CITY OF ALBUQUERQUE

January 31, 2017

Re: McDonalds – Coors & Hanover
1501 Coors Blvd NW
Traffic Circulation Layout
Engineer's/Architect's Stamp XX-XX-XX (J11-D037)

Based upon the information provided in your submittal received 01-25-17, the above referenced plan cannot be approved for Building Permit until the following comments are addressed:

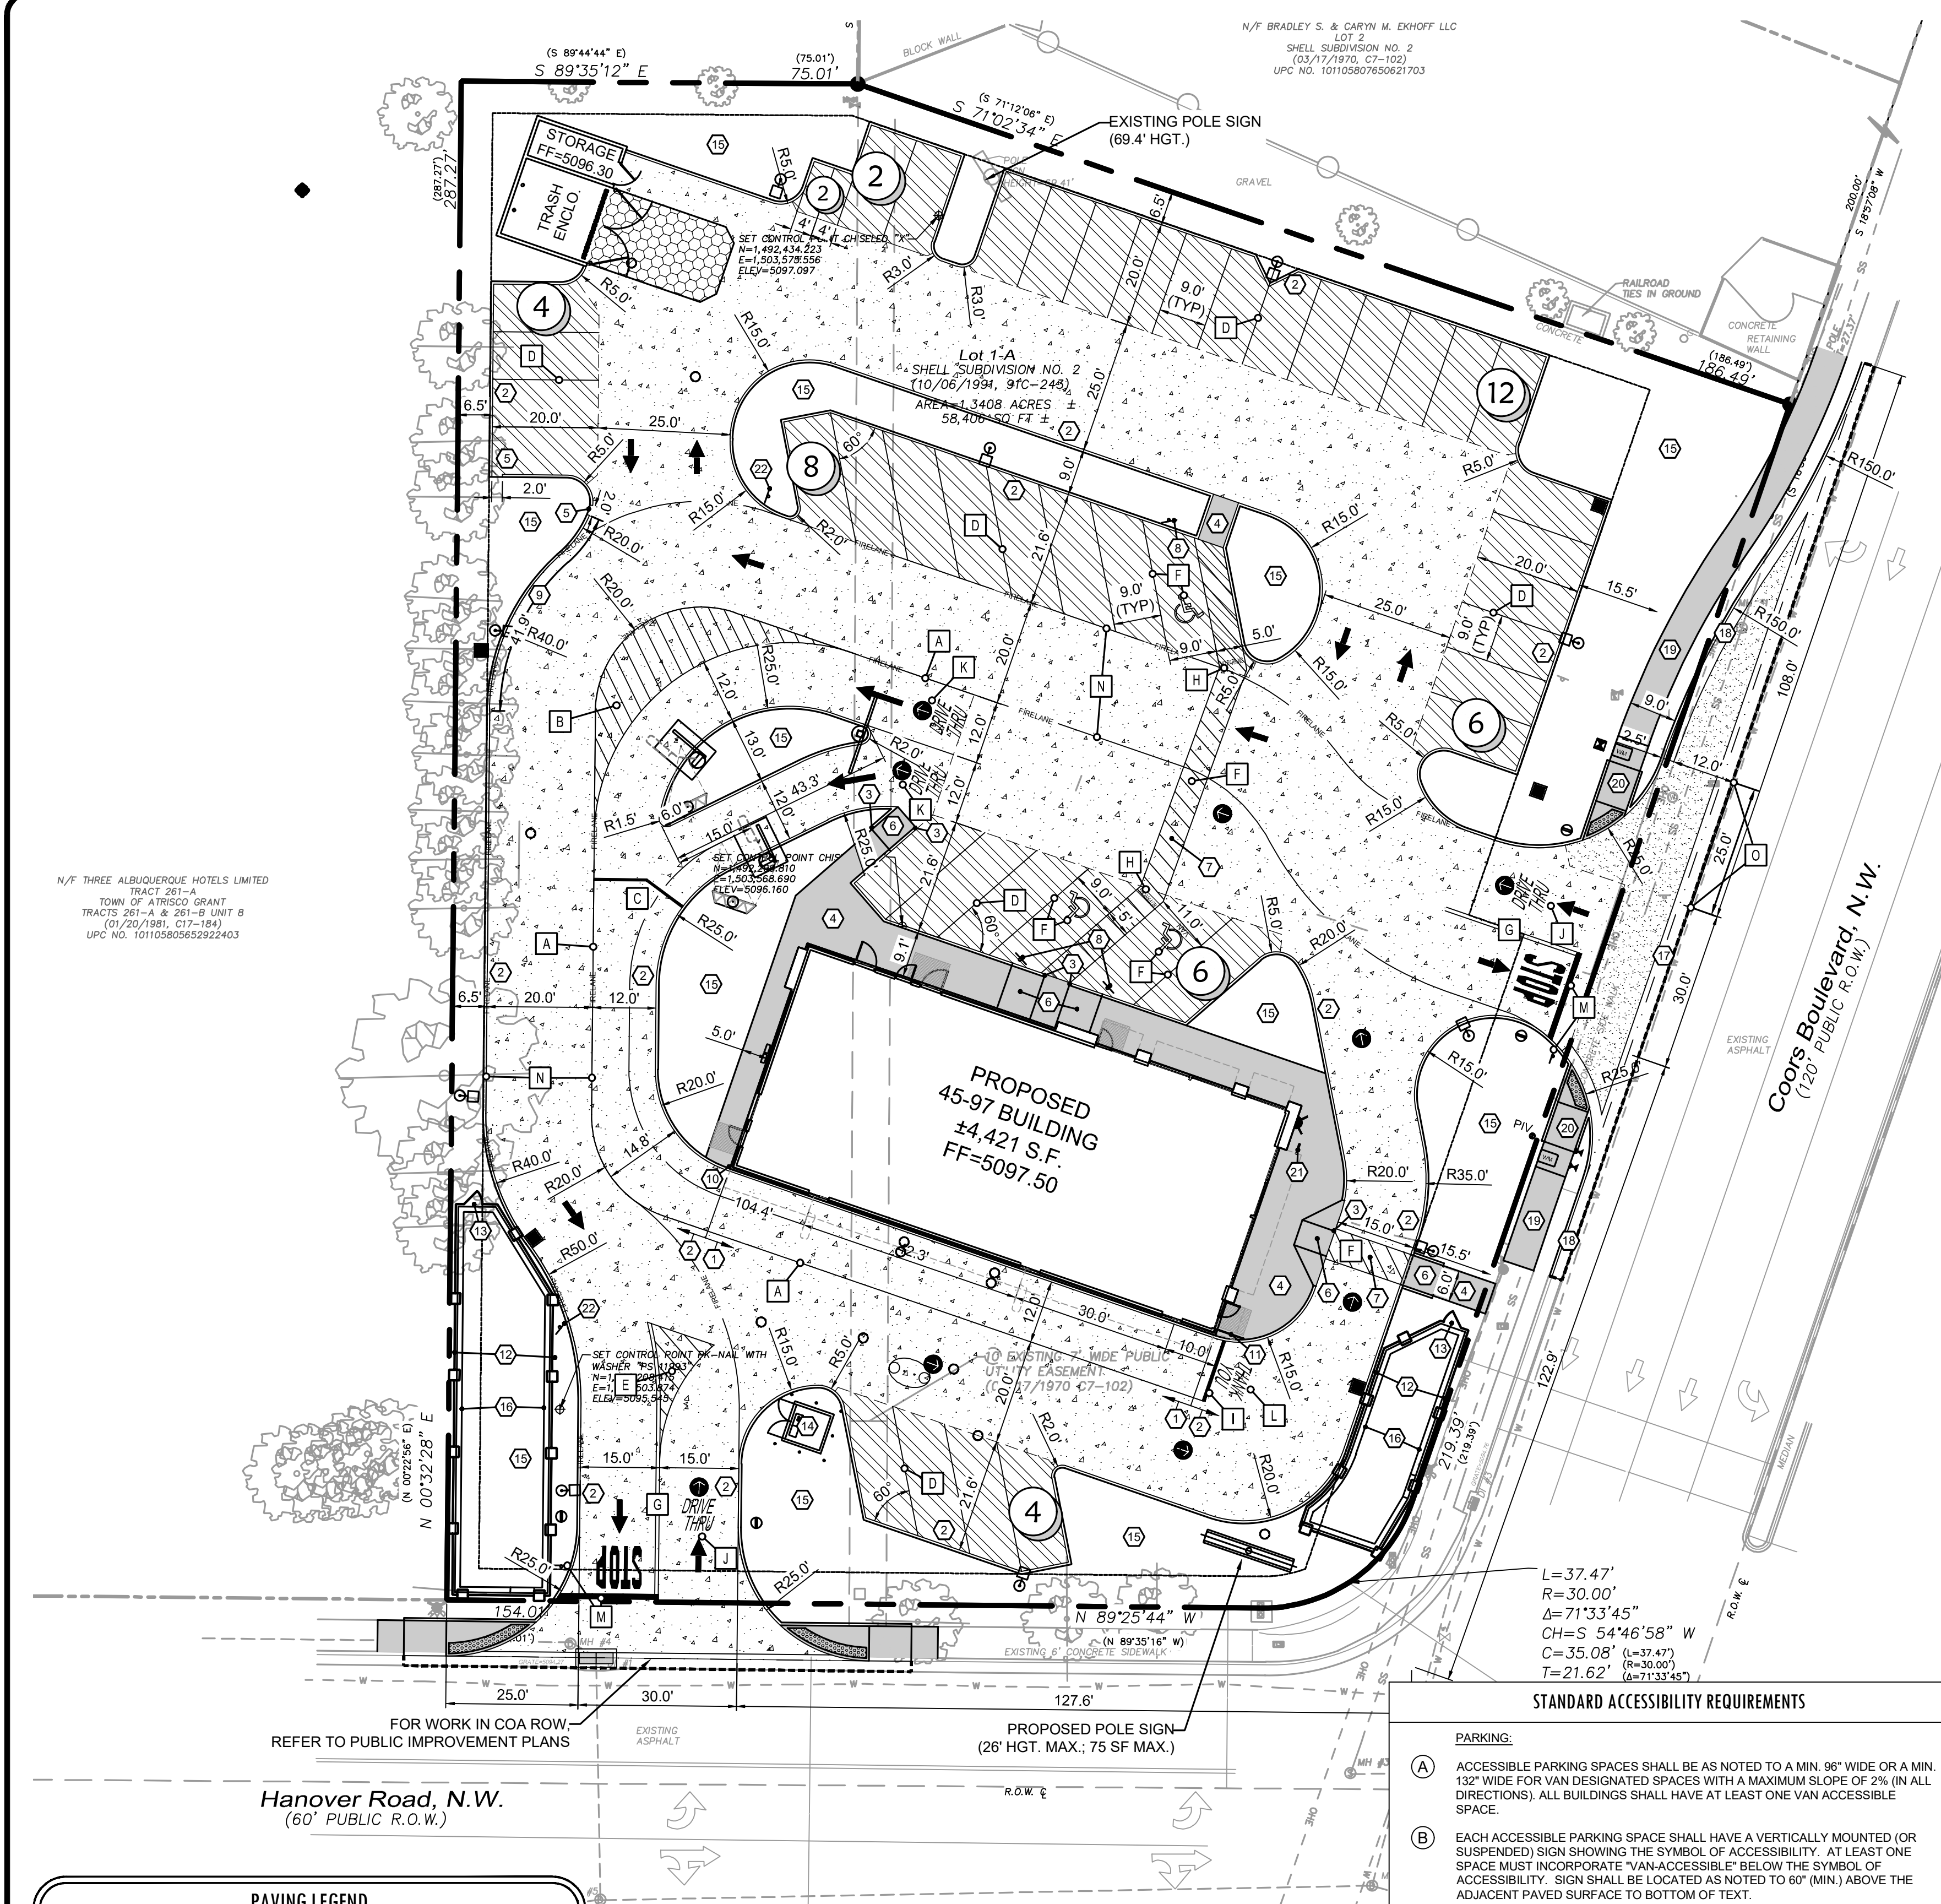
1. The traffic circulation layout must be stamped, signed, and dated by an engineer or architect licensed in the state of New Mexico.
2. Please provide the angle of the angled parking.

3. The ADA accessible parking sign must have the required language per 66-7-352.4C NMSA 1978 **"Violators Are Subject to a Fine and/or Towing."** Please call out detail and location of HC signs.

4. The ADA access aisles shall have the words **"NO PARKING"** in capital letters, each of which shall be at least one foot high and at least two inches wide, placed at the rear of the parking space so as to be close to where an adjacent vehicle's rear tire would be placed. (66-1-4.1.B NMSA 1978)

5. Provide a min 6" or max 8" high concrete barrier curb or other acceptable barrier between handicap parking and the sign in front of the building or move signs to sidewalk. Please call out detail and location of barrier curb.

6. One-way vehicular paths require pavement directional signage and a posted **"Do Not Enter"** sign at the point of egress. Please show detail and location of posted signs.

7. Please provide the detail sheet showing the standard details for the site.
8. Please provide additional information on the ADA curb ramps off of Hanover. Such as key note like the ones off Coors and clearly identify the radii. Will there be a work order for the ramps?
